From: Anita Gardner
Sent: 07 February 2019 16:13
To: Planning.Responses
Subject: FW: LU/2/19/PL; Unit 1 Lineside Way Littlehampton
Attachments: Unit 1 Proposed plus Silos Jan 2019.pdf

From: Wayne Gosden [REDACTED]
Sent: 07 February 2019 15:54
To: Anita Gardner
Subject: LU/2/19/PL; Unit 1 Lineside Way Littlehampton

I write to request the original proposed plans and elevations be withdrawn and substituted for the attached drawings.

Title: Plans and Elevations - Proposed and Notes

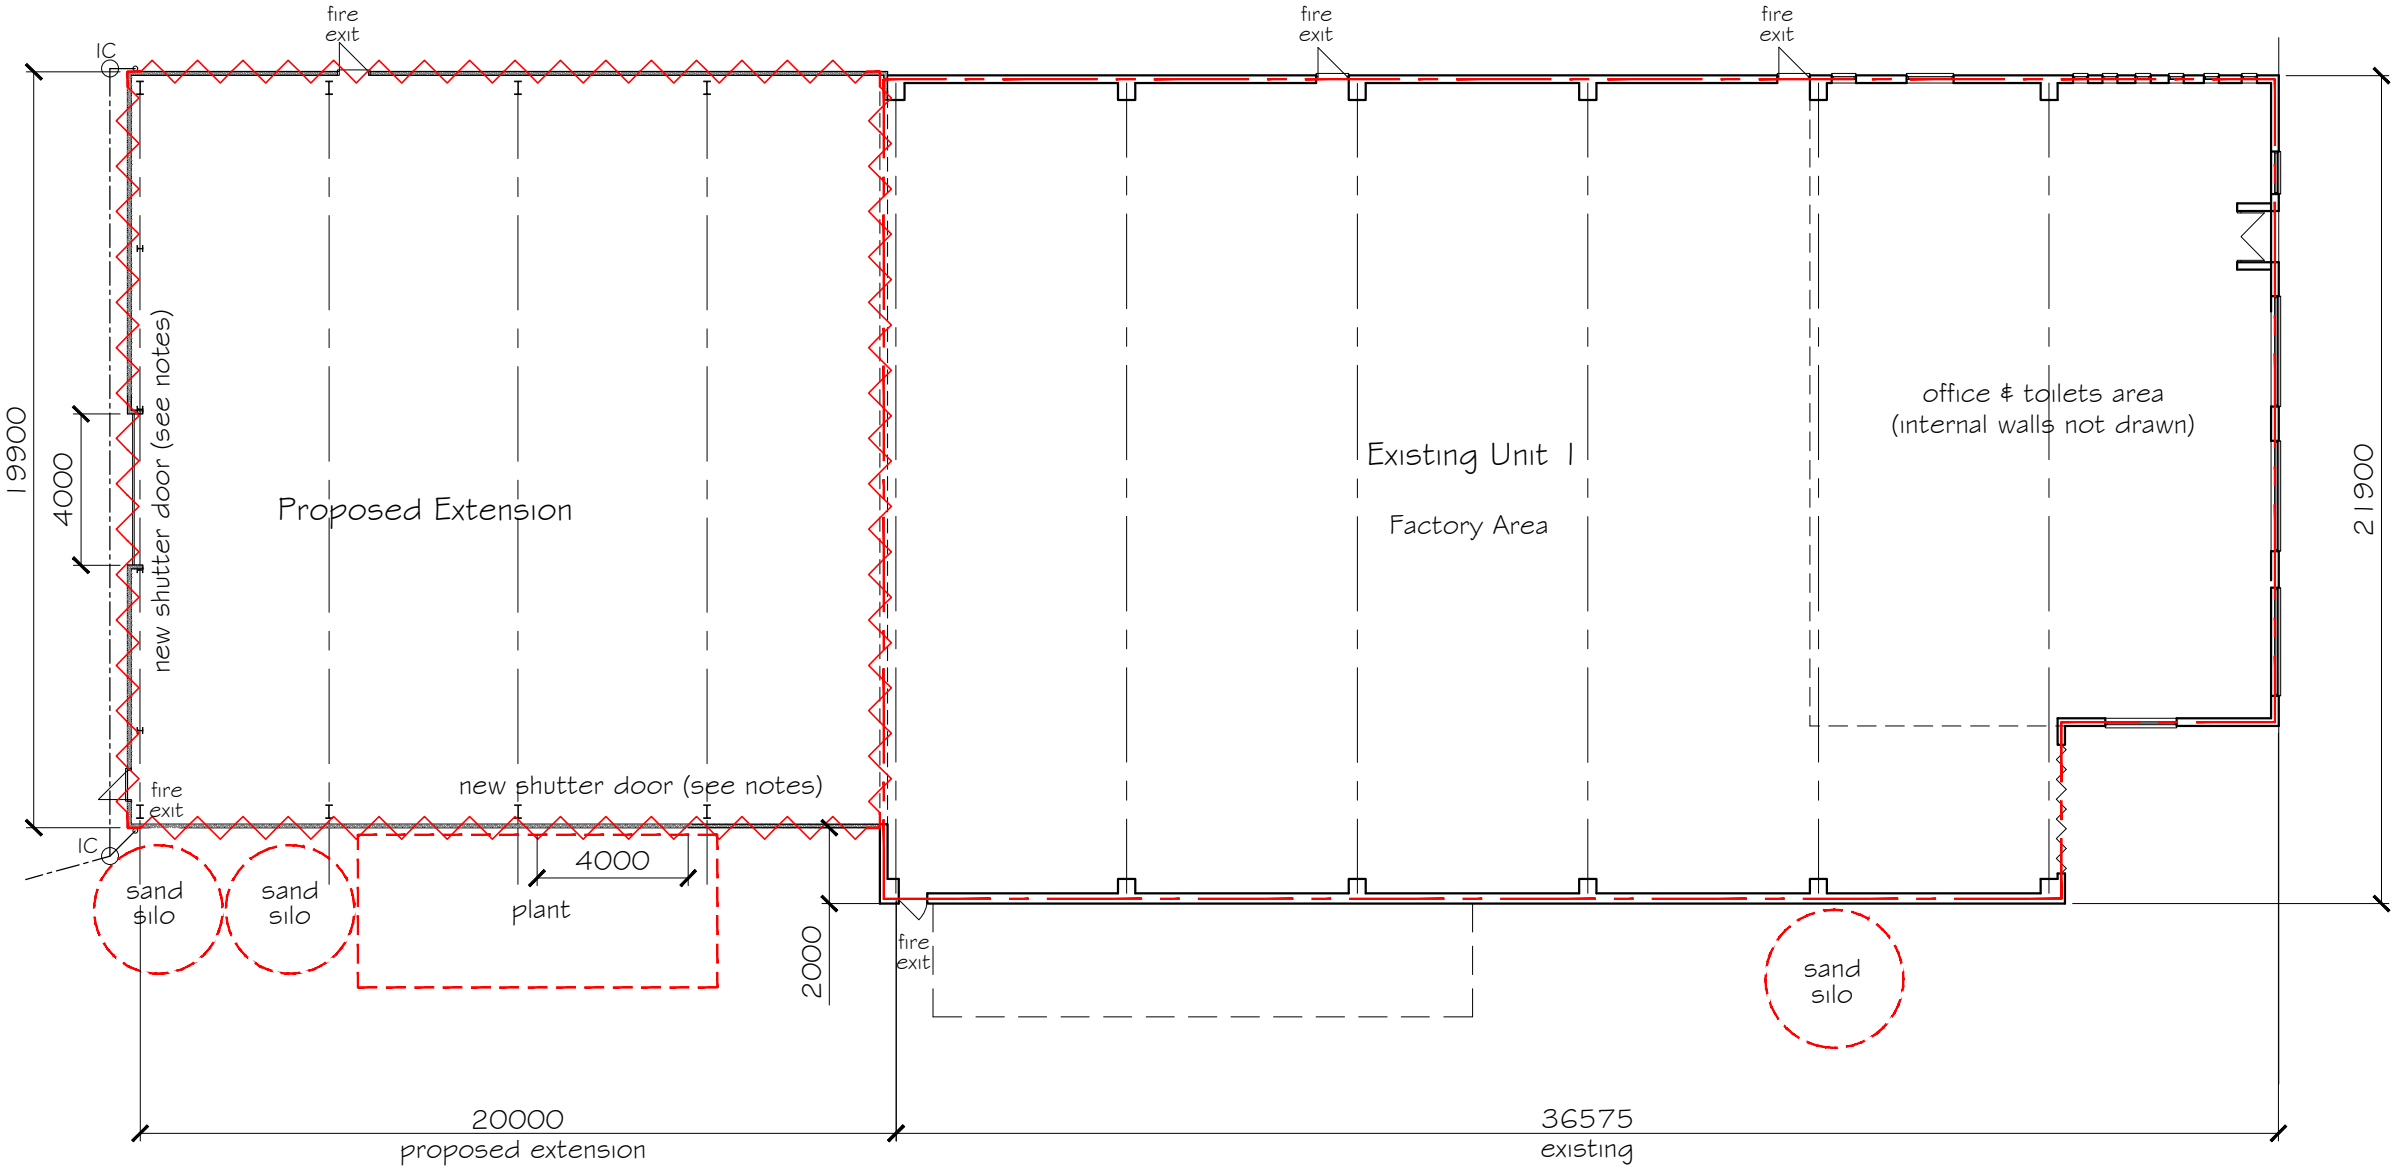
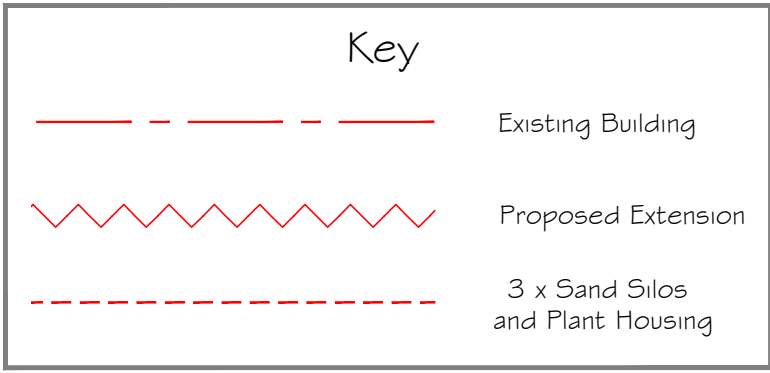
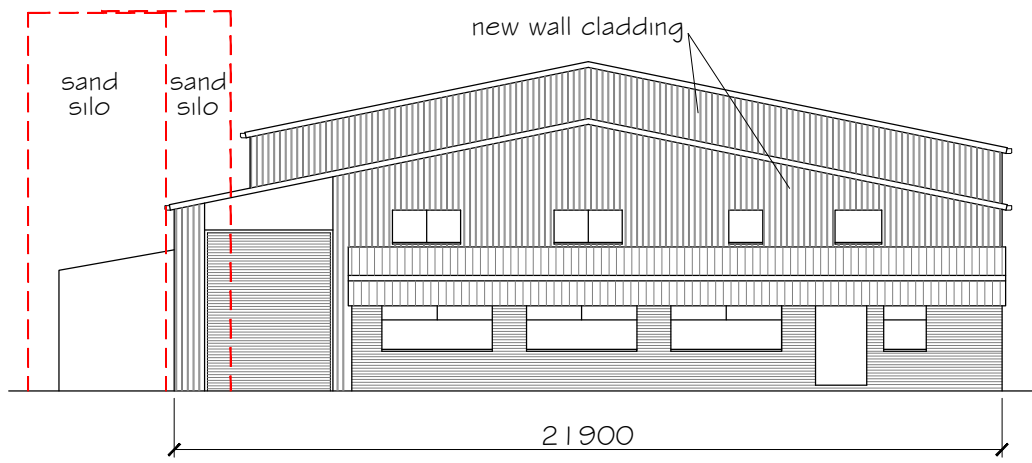
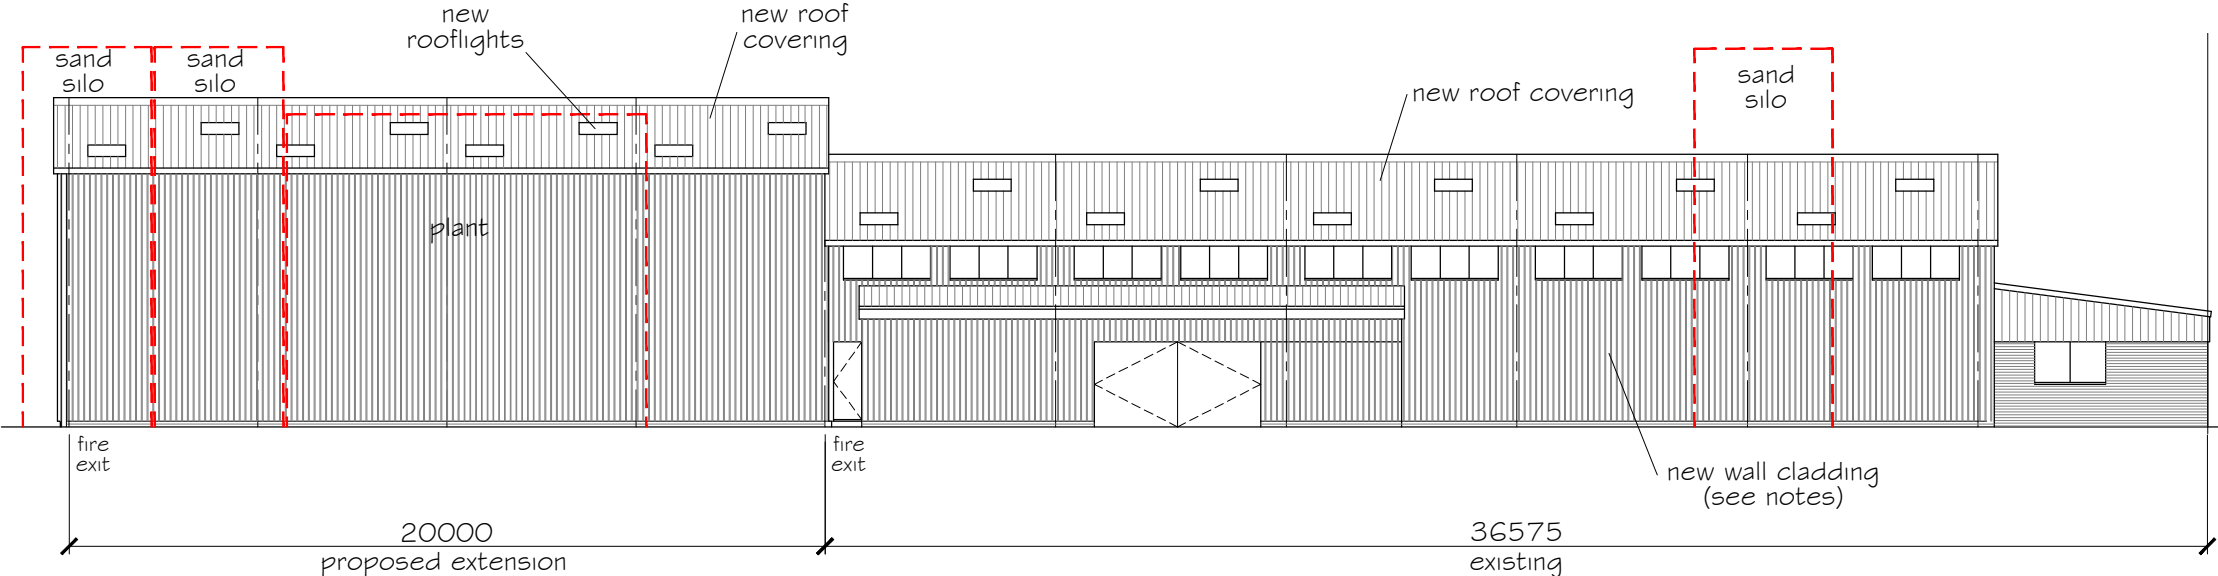
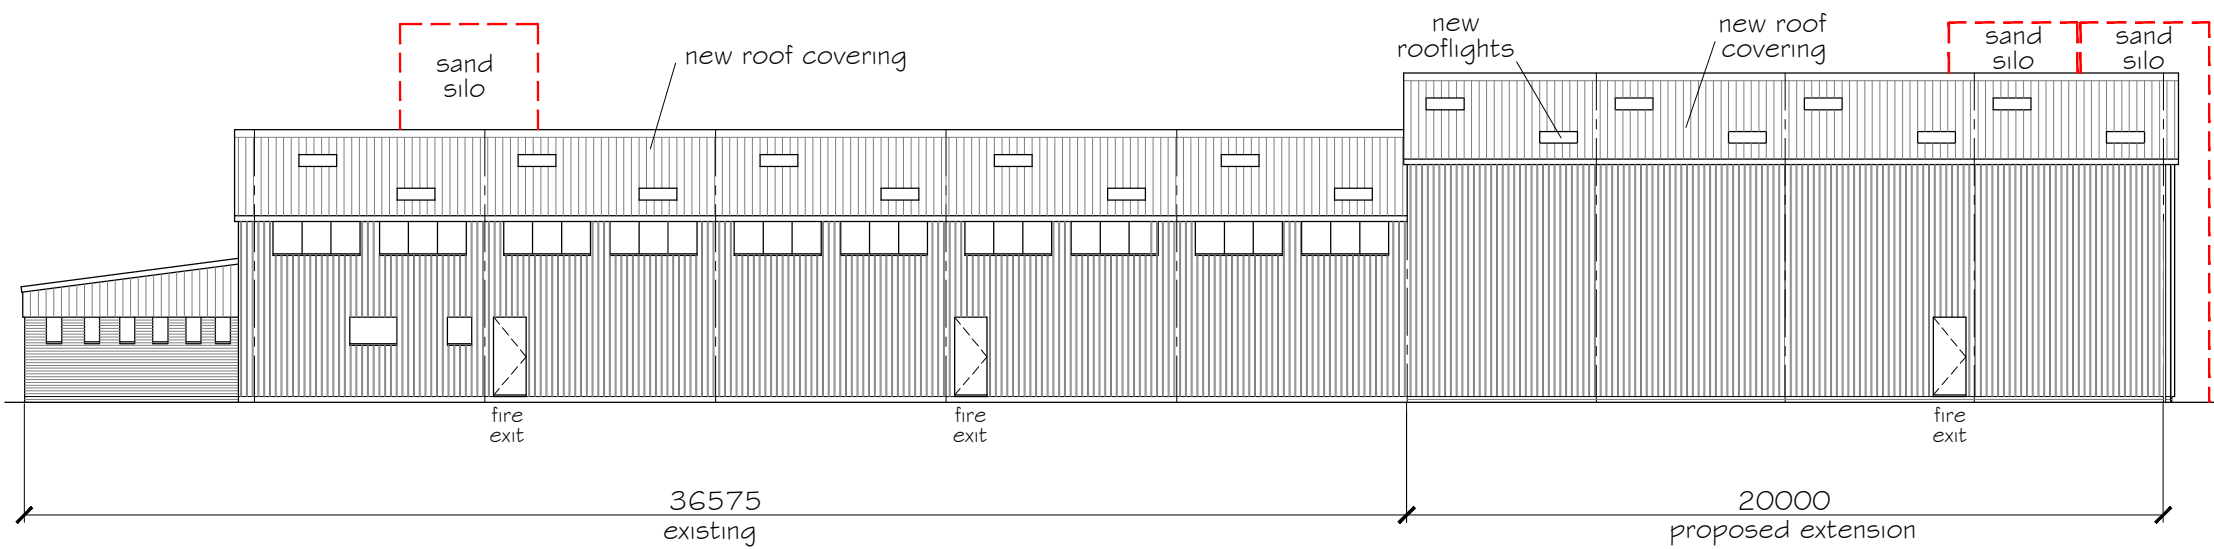
Essentially client has had site freeholder impose a change to the west elevation but that also the client request is to raise the existing roof profile so the ridge height increases and also the addition of business critical sand silos and associated plant room
